WEST SUSSEX COUNTY COUNCIL CONSULTATION

TO:	Arun District Council FAO: Simon Davis
FROM:	WSCC - Highways Authority
DATE:	8 April 2019
LOCATION:	26 Burnham Avenue Bognor Regis PO21 2JU
SUBJECT:	BR/49/19/OUT Outline application with all matters reserved for 22 No. new dwellings consisting of 2 No. 1 bed dwellings, 18 No. 2 bed dwellings & 2 No. 3 bed dwellings.
DATE OF SITE VISIT:	
RECOMMENDATION:	Advice/ More Information Required
S106 CONTRIBUTION TOTAL:	£ See response sent 04/04/2019

Roof / Site Plan (Proposed) 1:200

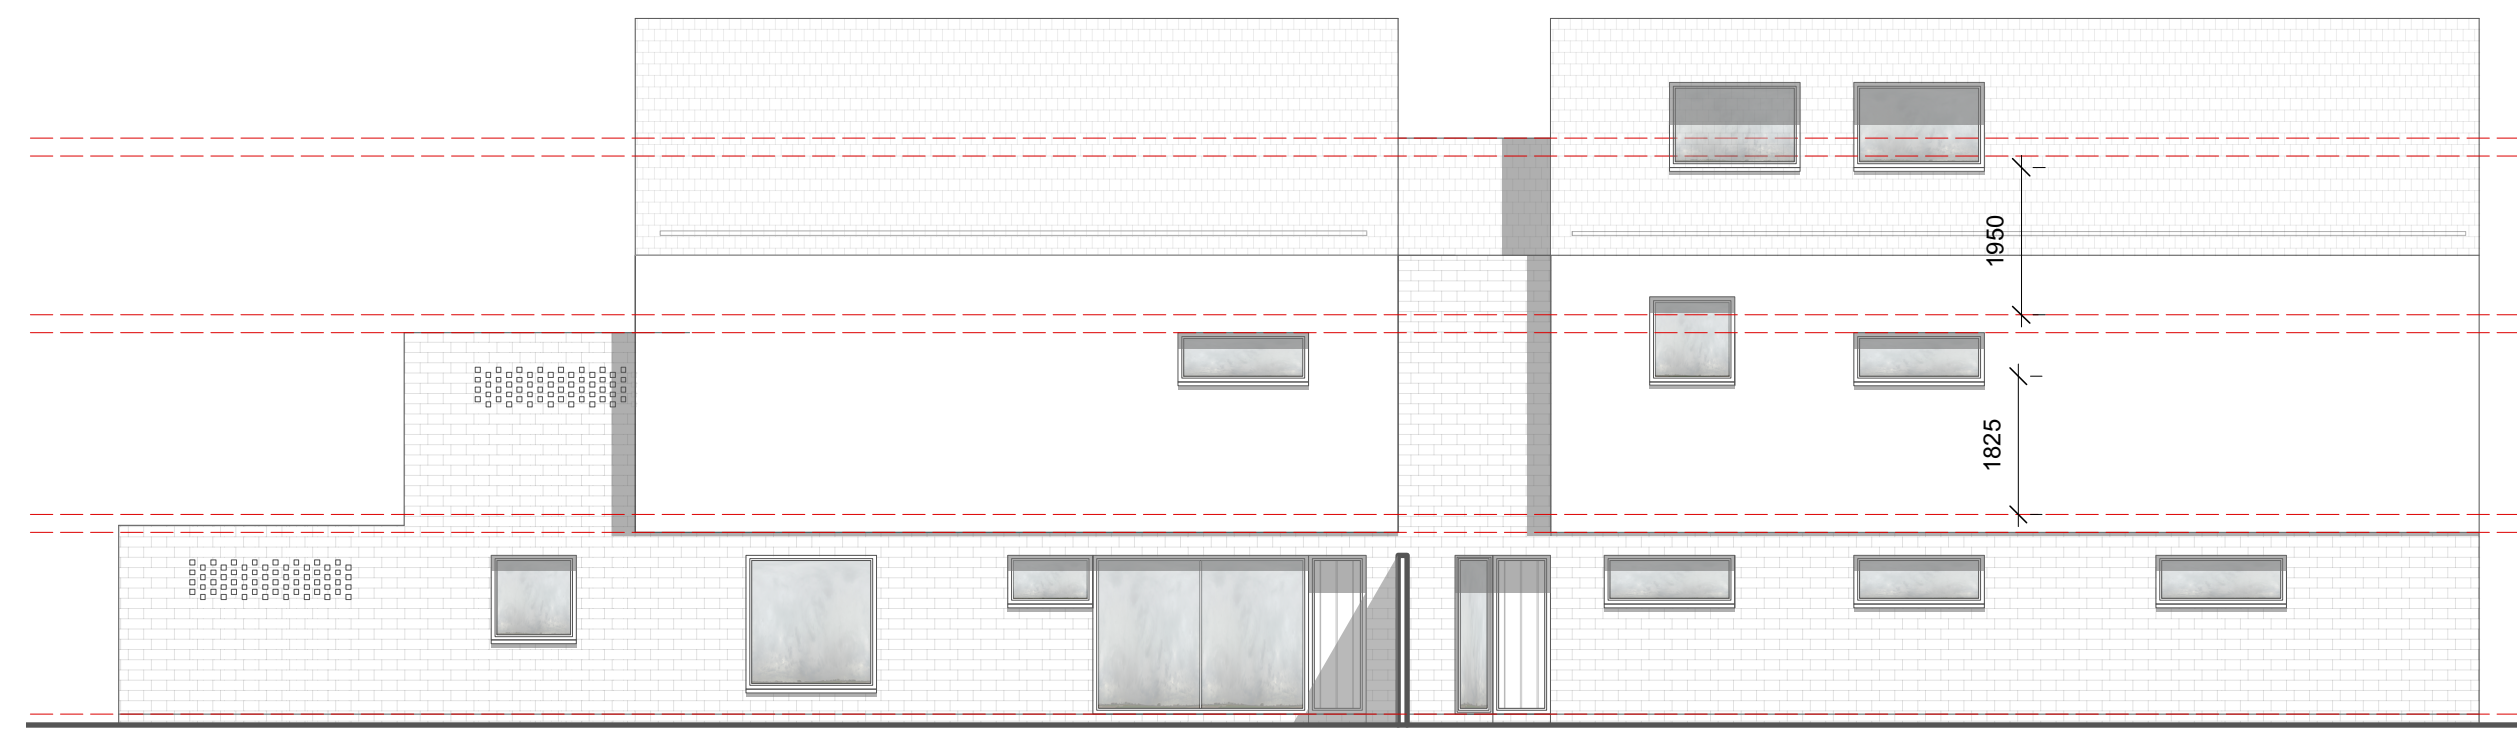
Given the sustainable location of the development and the proximity to the National Cycle Route no. 2 from Bognor Regis to Littlehampton it is considered that at a minimum a single cycle parking space per unit would be sufficient to serve this development. I note that the current plans show 20 cycle parking spaces so at minimum we would expect two additional cycle parking spaces to be provided. These details can be provided at the reserved matters phase.

I also advise that plans will need to be submitted at reserved matters demonstrating the closing off of the existing access point to the dwelling from the publicly maintained highway, this will need to be completed with a license from the Arun Area Highways Manager and to WSCC Standards.
